14/11/2019

**Bulga Coal Optimisation Project (SSD 4960 MOD 3)/
Bulga Underground Mine (DA 376-8-2003 MOD 7)
Request for Submissions Report**

Bulga Coal Optimisation Project (SSD 4960 Mod 3) and Bulga Underground (DA 376-8-2003 MOD 7) Request for Response to Submissions

APPENDIX 12
CONCEPTUAL PROFILE OF THE NOISE AND VISUAL BUND

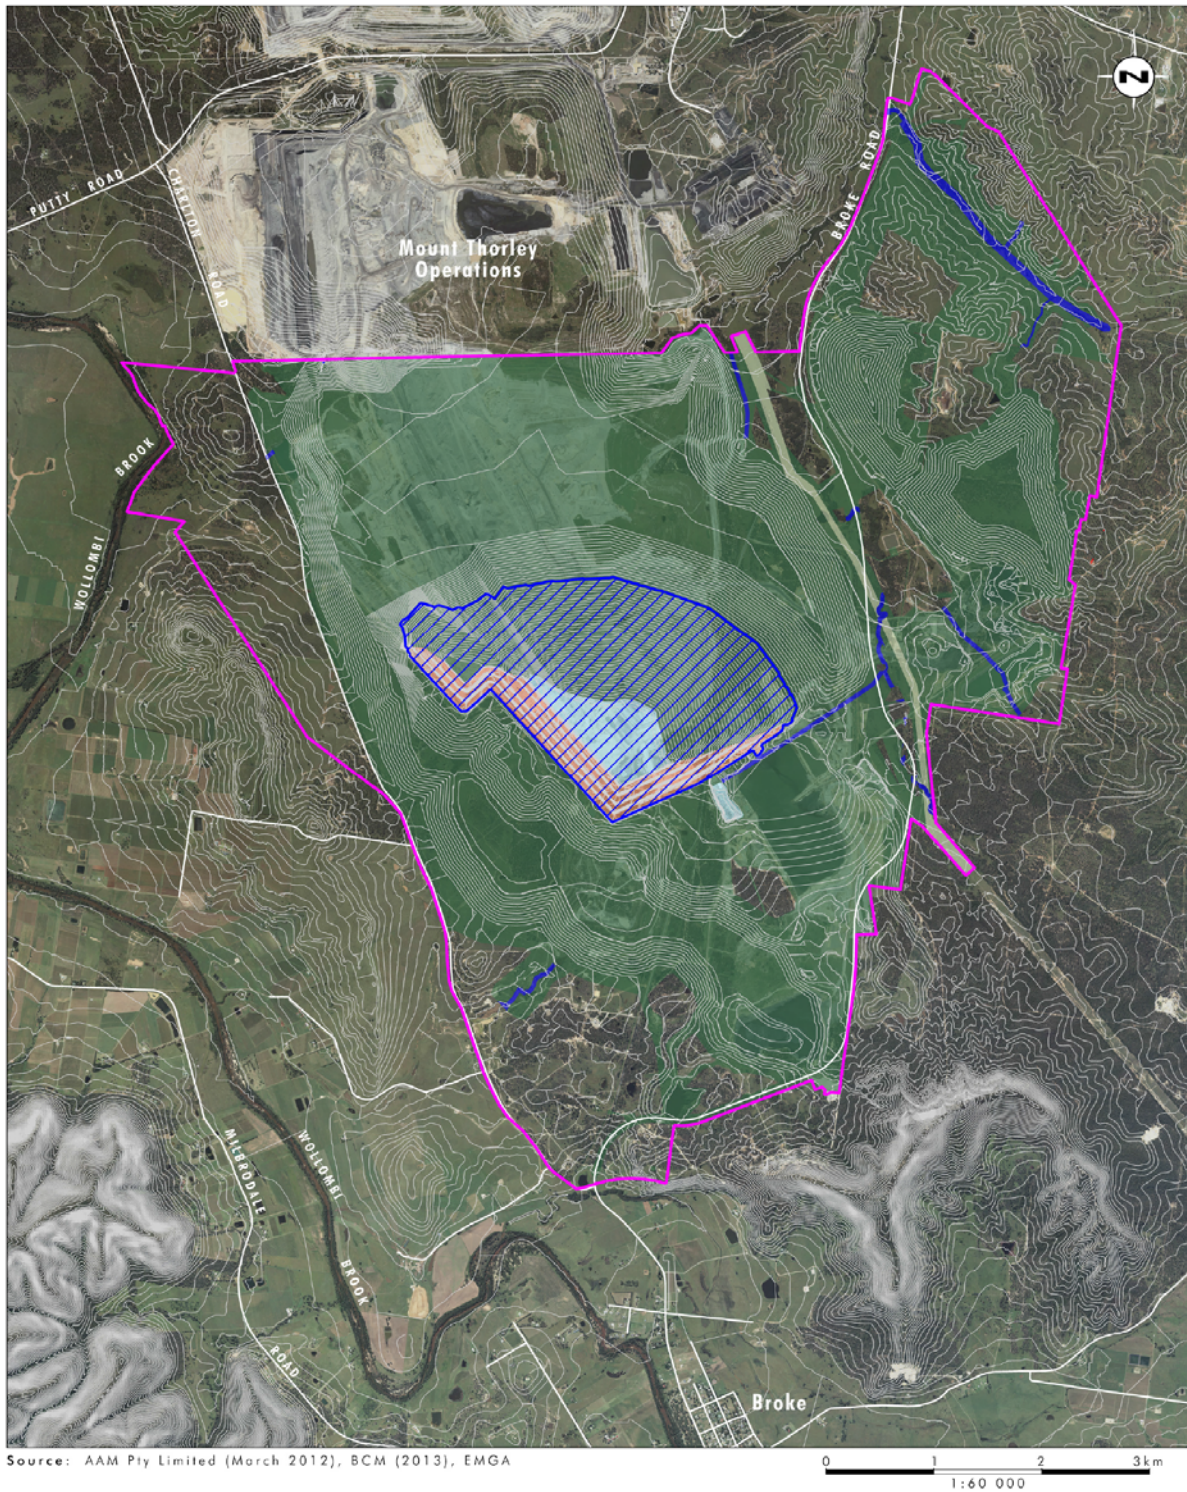
Social Impacts	Singleton Council considers that the impacts on the community, particularly tourism, have not been adequately addressed. Please provide a detailed response to Council's submission, including further consideration of the how an extended period of mining and increase in disturbance footprint may impact upon the community. The Department notes that Council has met with Glencore regarding revising its existing Voluntary Planning Agreement. The Department requests to be kept informed of the progression of these discussions and to be advised of any revised terms prior to determination.
Figures	<p>Figure 3.6 provides depth of extraction cross-sections. In addition, the Department requests a figure representing a cross-section of the targeted coal seams and the proposed maximum depth of extraction including any interactions with underground workings and their depths.</p> <p>Visual Impacts - Section 6.8 of the SEE notes that infrastructure will be relocated to an area south of the noise and visual bund, and references Figure 3.8. However, the noise and visual bund is not shown on this figure. Please provide a figure representing the proposed placement area for the infrastructure in relation to the noise and visual bund.</p>
